FIRE RISK MANAGEMENT, INC.

Memo Report

Subject: Fire Protection & Life Safety Code Assessment: 5 Sherman Street, Portland, ME

**Proposed Plan Lvl 1**  
1/4" = 1' - 0"  
06.12.2017

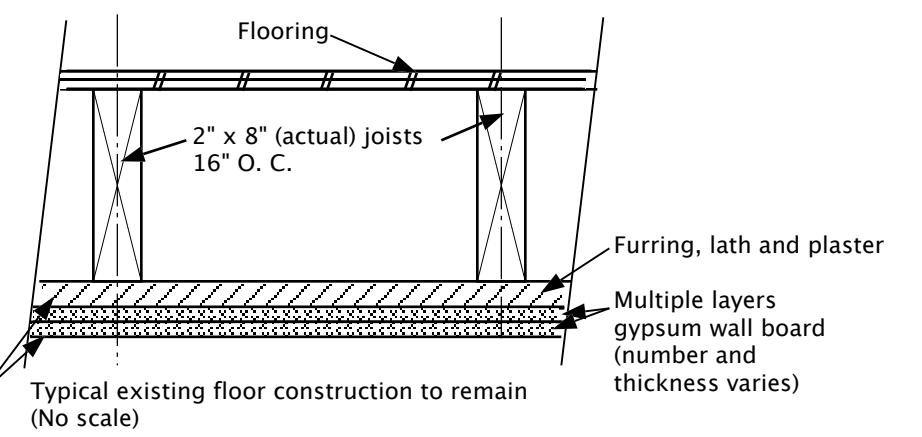
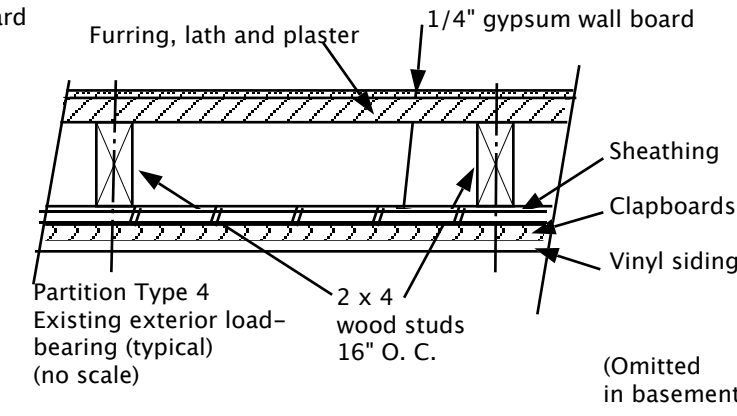
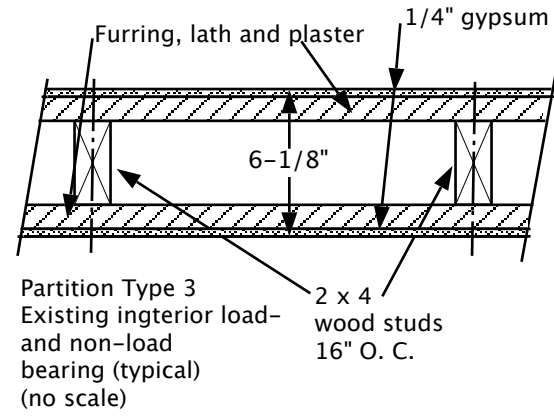
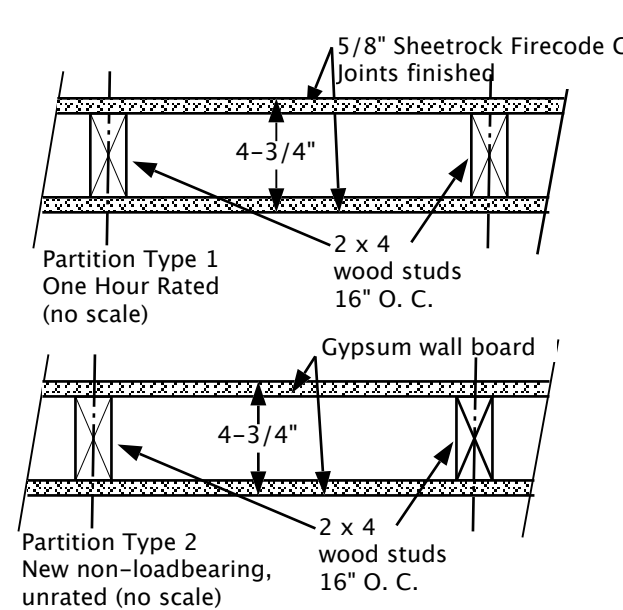
The first floor is currently provided with three exits. However, with the creation of a single apartment, the third exit is no longer necessary or required. The existing wall of the rear exit enclosure is to be relocated to capture the unused space. The modified wall is required maintain the 1-hour fire resistance rating for the exit enclosure. The wall modification will not affect the existing exit, including no changes to door or stair widths.

Based on our review of the building and the proposed renovation plans provided, the building is currently compliant with the applicable codes. In connection with the renovation of the 1st floor level, it will be necessary to ensure that the modified wall adjacent to the rear exit enclosure will continue to provide a 1-hour fire separation with the 1st floor apartment. Equally, it will be necessary to ensure that the required smoke detectors within the 1st floor apartment will be interconnected and "hard wired." Similarly, a properly installed CO detector(s) will also be required within the new apartment. The State requires that
